2019/0531—New Parking (VMS) Signs @ Barnsley Hospital NHS Trust

Following review of the above referenced application and in light of the comments received from the Planning and Highways, we have revised our design proposal; taking on board feedback and comments raised from the initial submission, alongside consideration to our national design guidelines. We hope the below revised changes and explanation will be sufficient to reconsider this submission and progress this application. Please also refer to the attached Annex for the revised proposal:

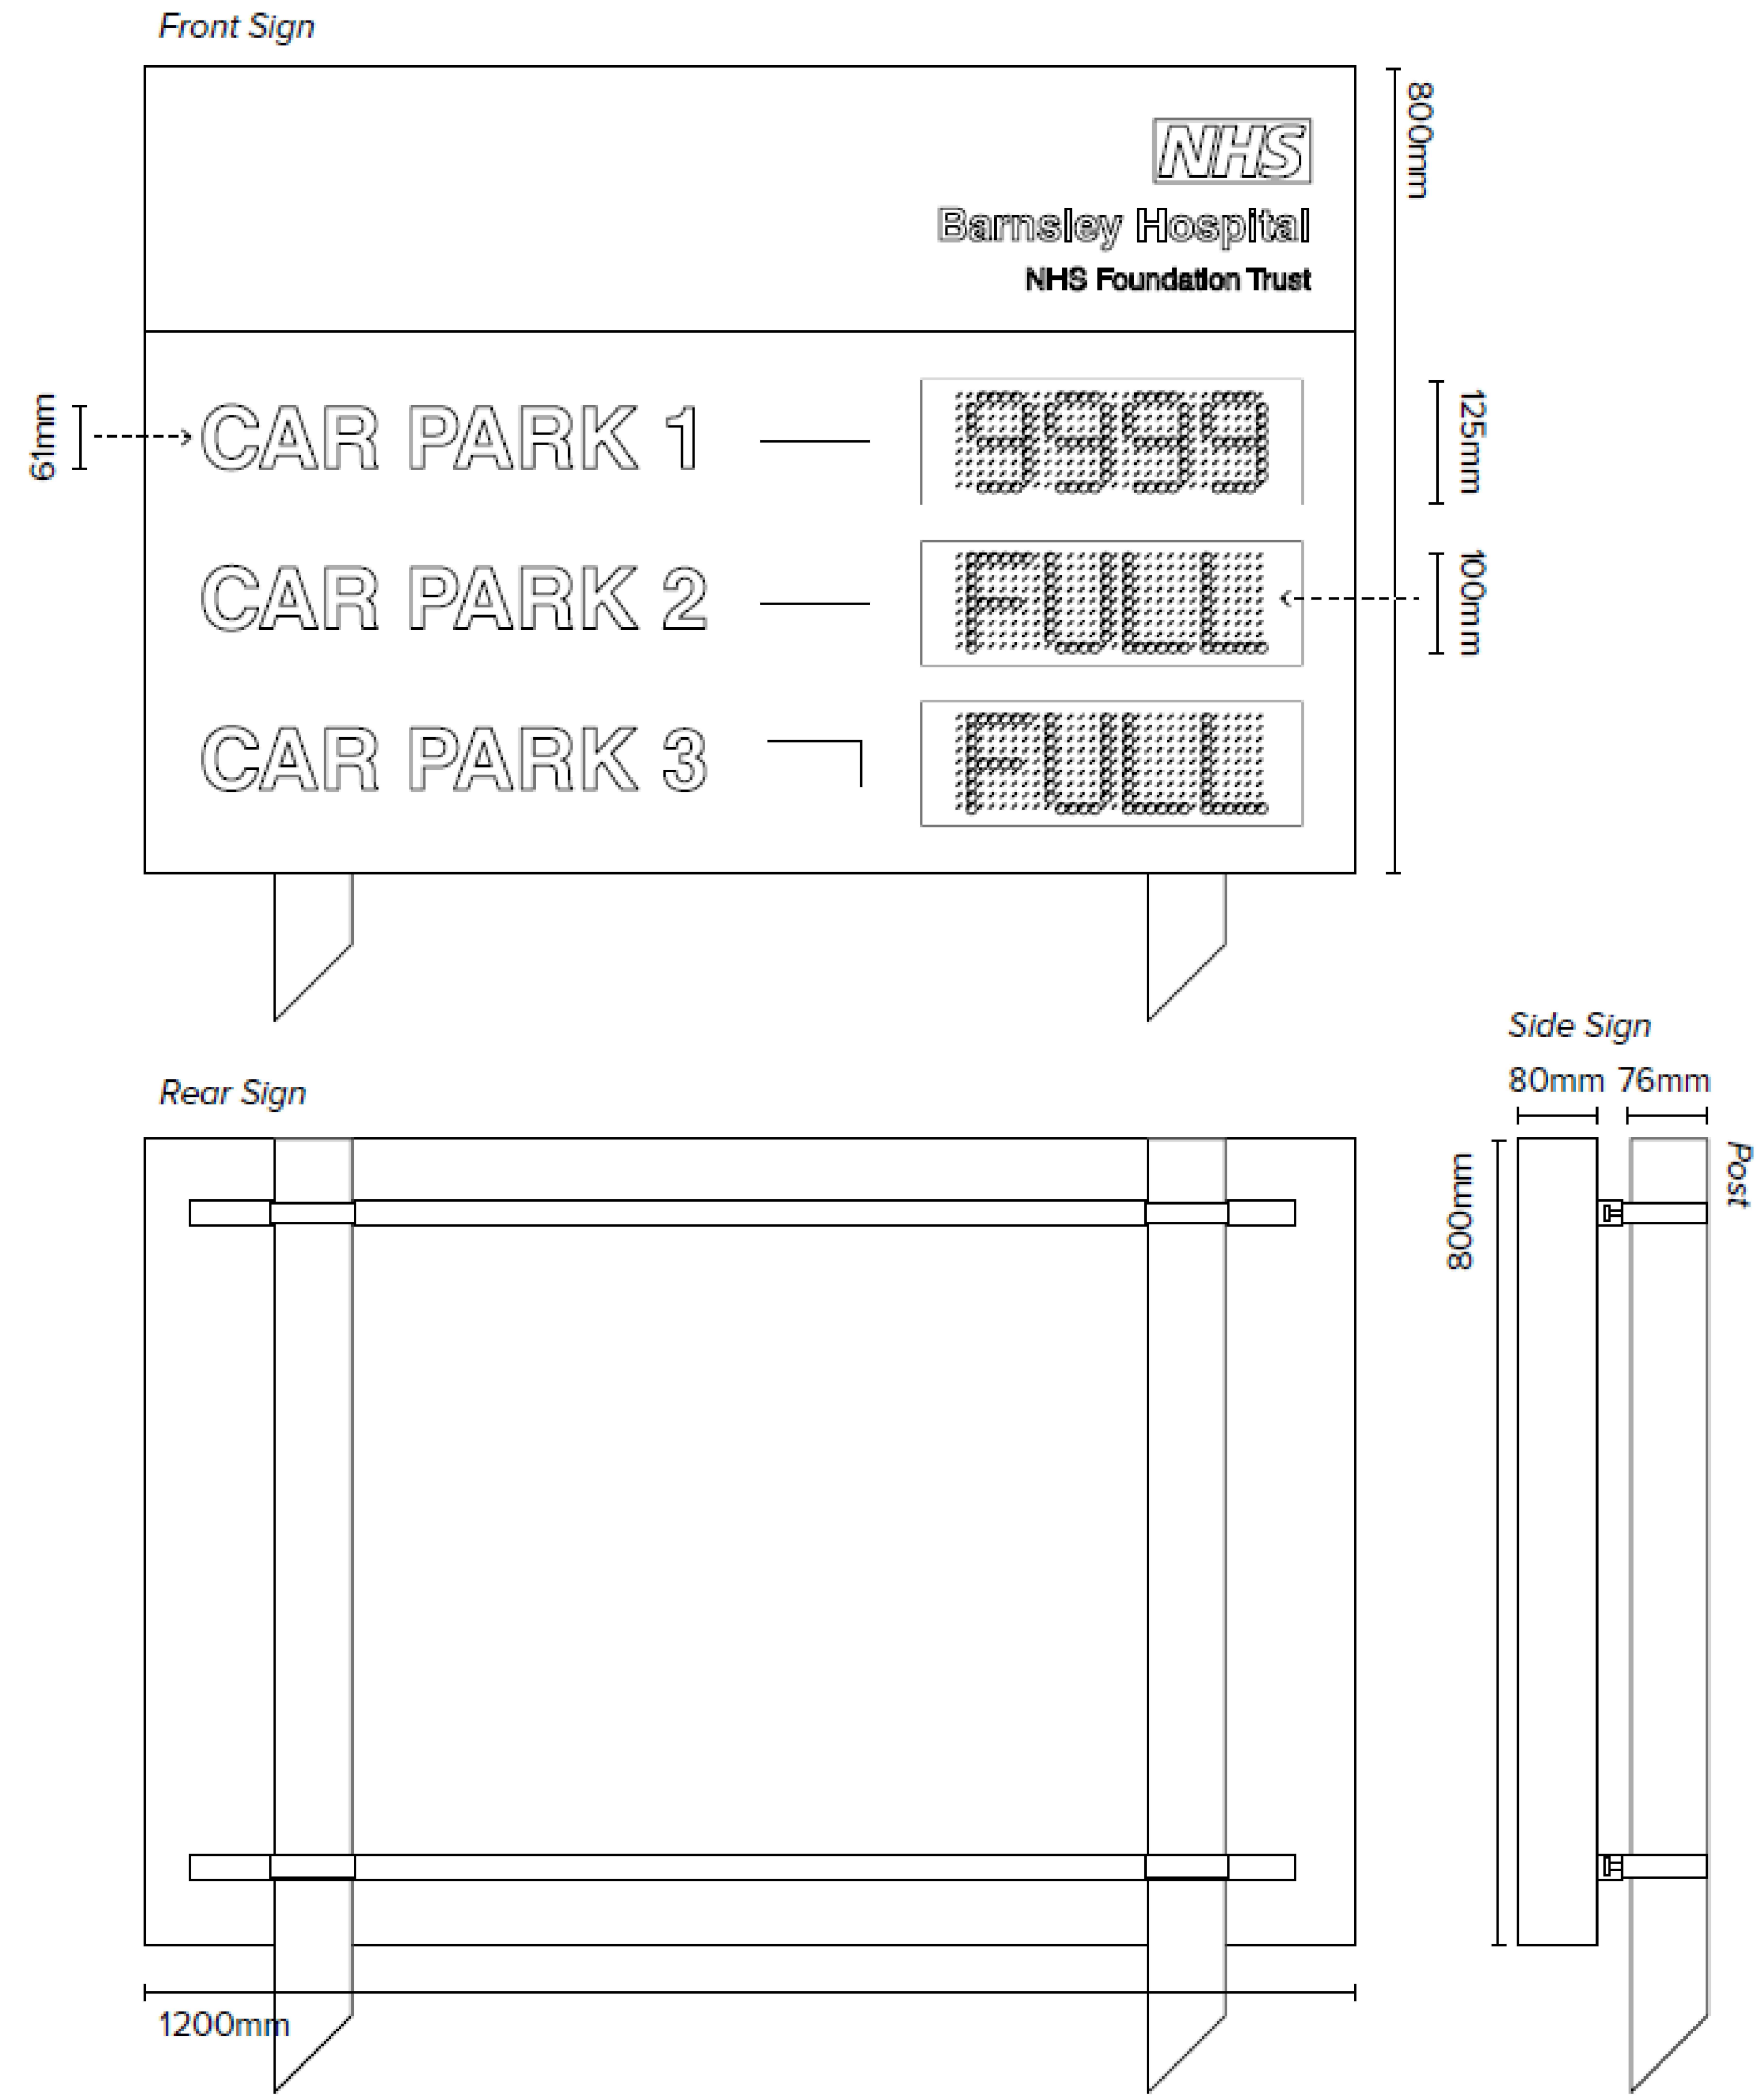
In light of the above and safety concern raised from the initial proposed submission, below are highlighted revised proposal for the location of the proposed Variable Message Signs (VMS) boards;

- Relocate the tariff information sign downstream (see Page 7) such that it is sited adjacent to the existing pay station i.e. out of view of Pogmoor road.
- The proposed VMS board will be installed as shown (Page 6) in clear view of the approach of Entrance A on Pogmoor Road.

- Remove 1no signboard currently displaying the 'Barnsley Hospital Charity' information (see page 8)
- Install 1no proposed VMS board as shown on page 9.
